**United Utilities Water Limited
Planning, Landscape and Ecology**
2nd Floor, Grasmere House
Lingley Mere Business Park
Lingley Green Avenue
Warrington
WA5 3LP

Your ref 3/2020/0498
Our ref DC/20/2644
Date 04-AUG-20

Location : Land to the North of Beech House Alston Lane Longridge PR3 3BN

Proposal : Proposed construction of three holiday cottages with associated parking and amenity areas

5335 - P04 D

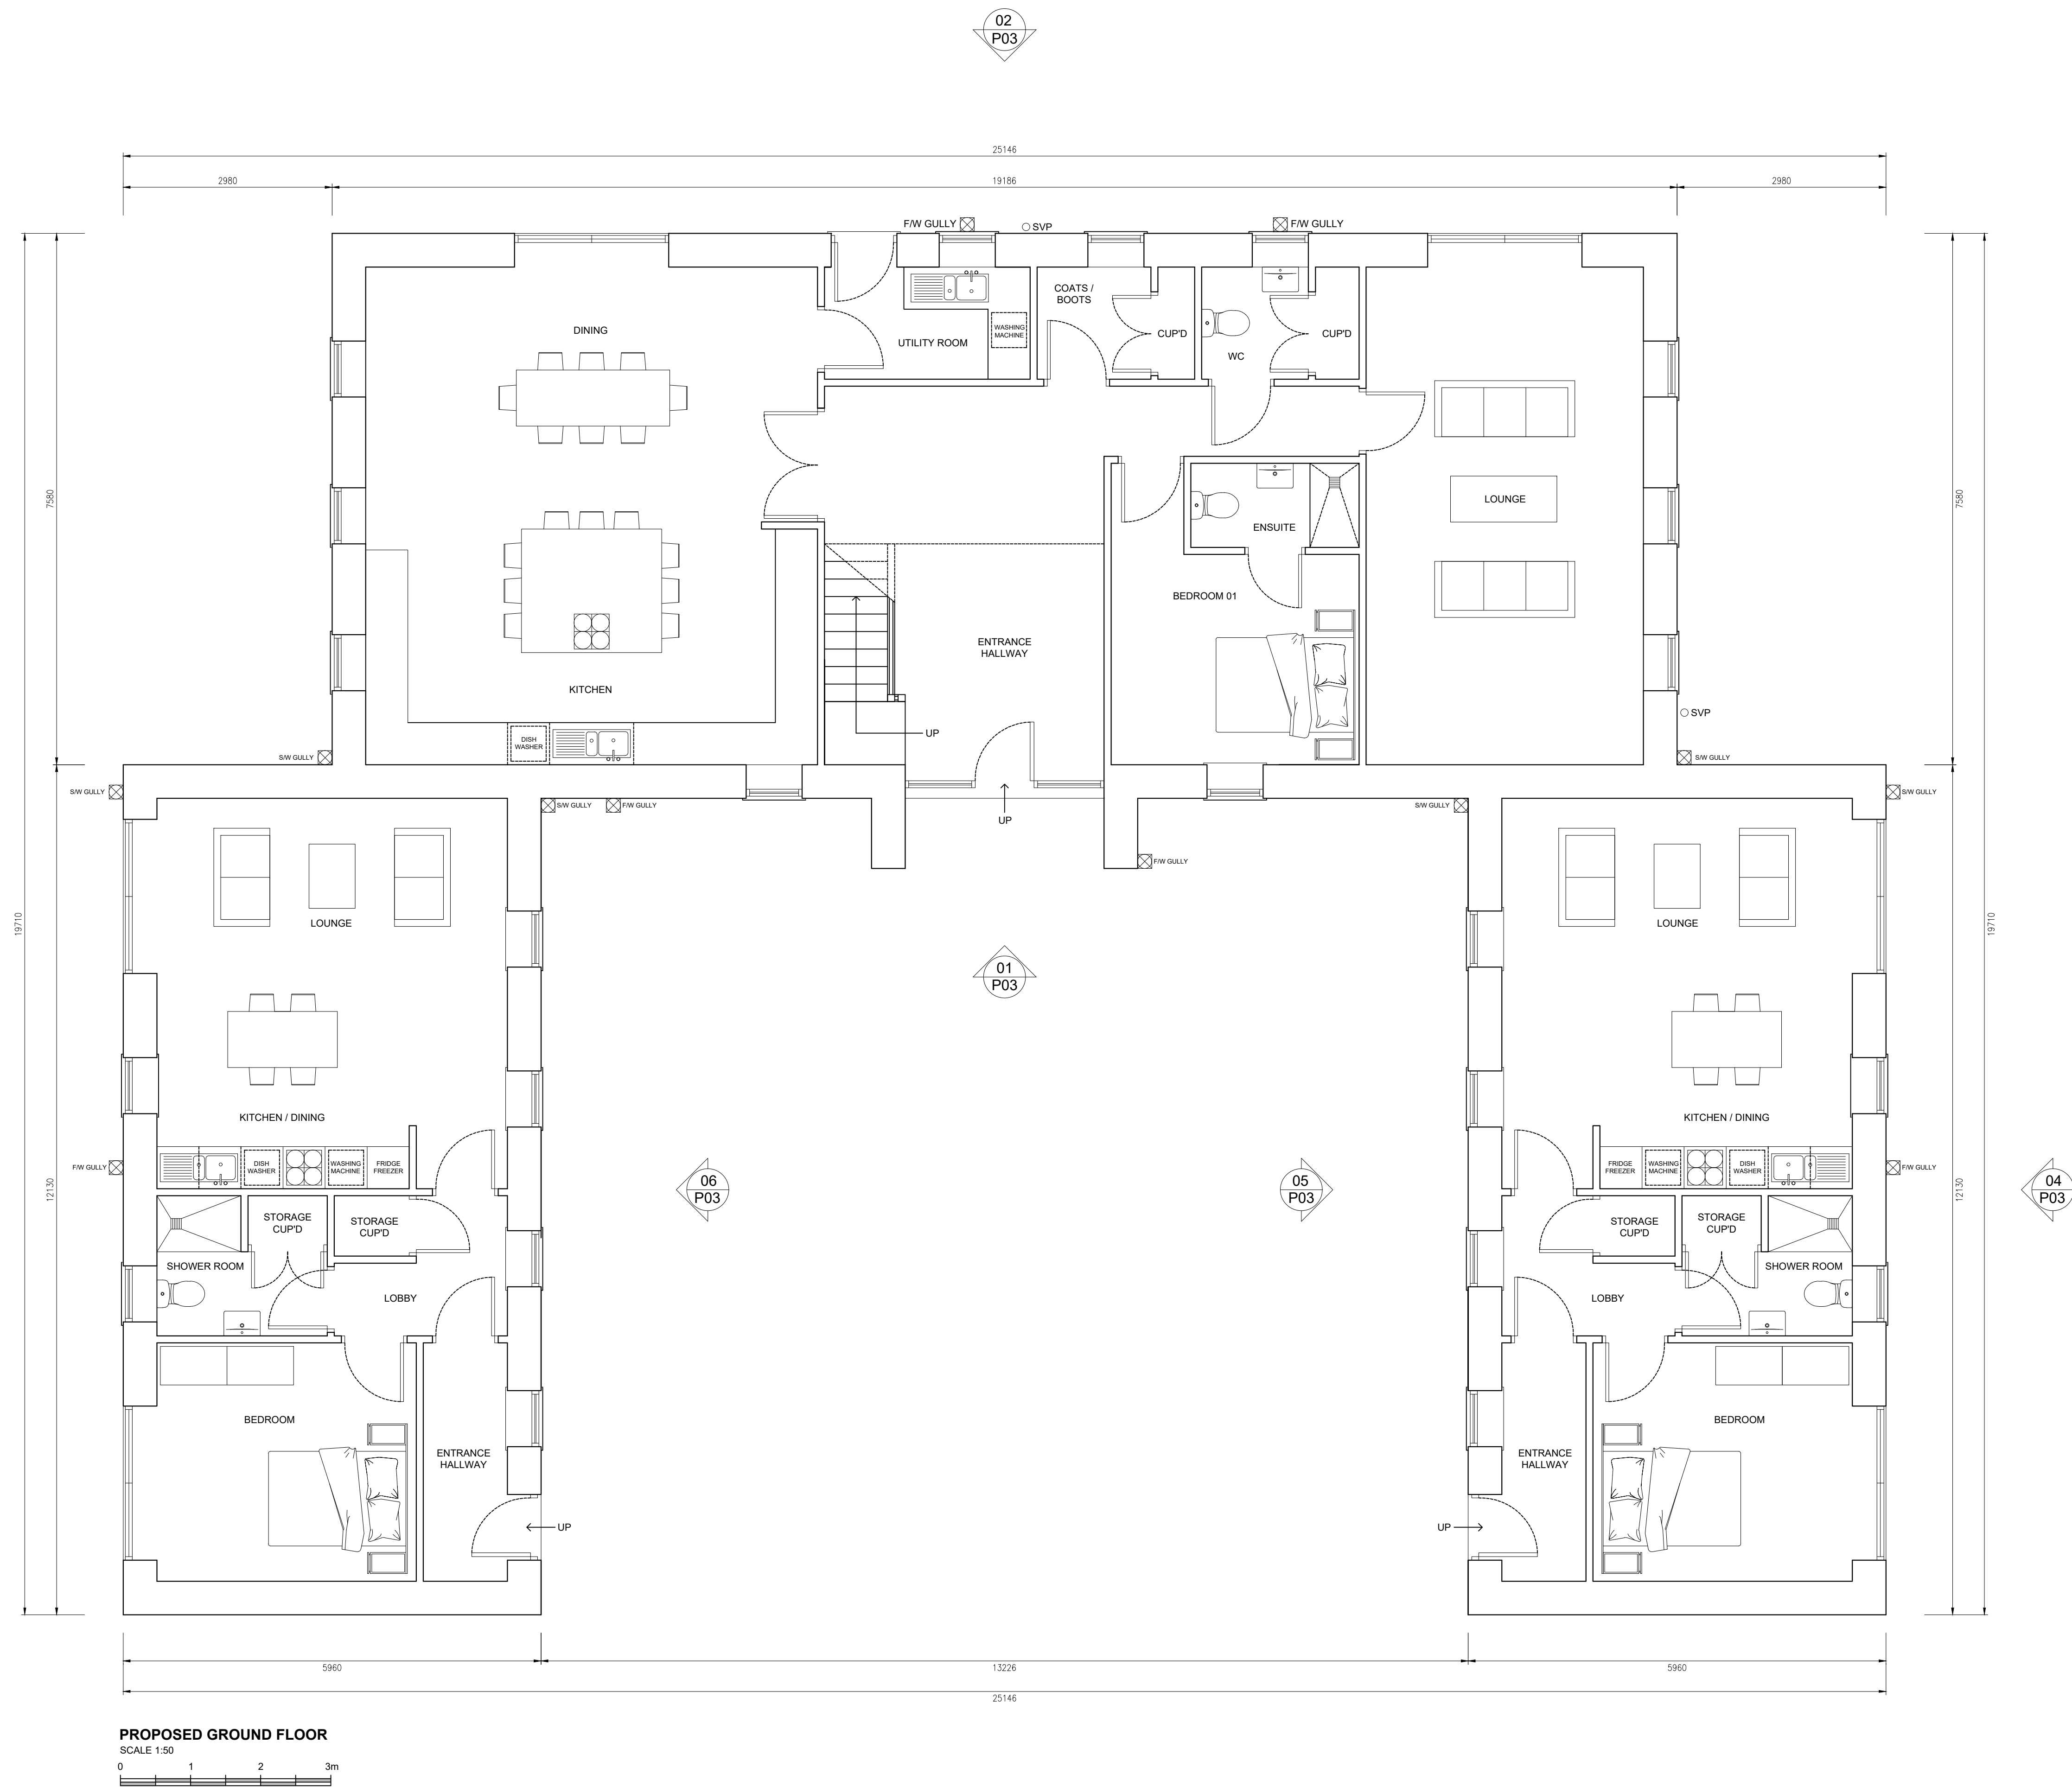
Following our review of the submitted Drainage Strategy, we can confirm the proposals are acceptable in principle to United Utilities and therefore should planning permission be granted we request the following condition is attached to any subsequent Decision Notice:

The drainage for the development hereby approved, shall be carried out in accordance with principles set out in the submitted Foul & Surface Water Drainage Design Drawing 5335-P04, Rev F - Dated 19/06/20 For the avoidance of doubt and unless otherwise agreed in writing by the Local Planning Authority, no surface water will be permitted to drain directly or indirectly into the public sewer. The development shall be completed in accordance with the approved details.
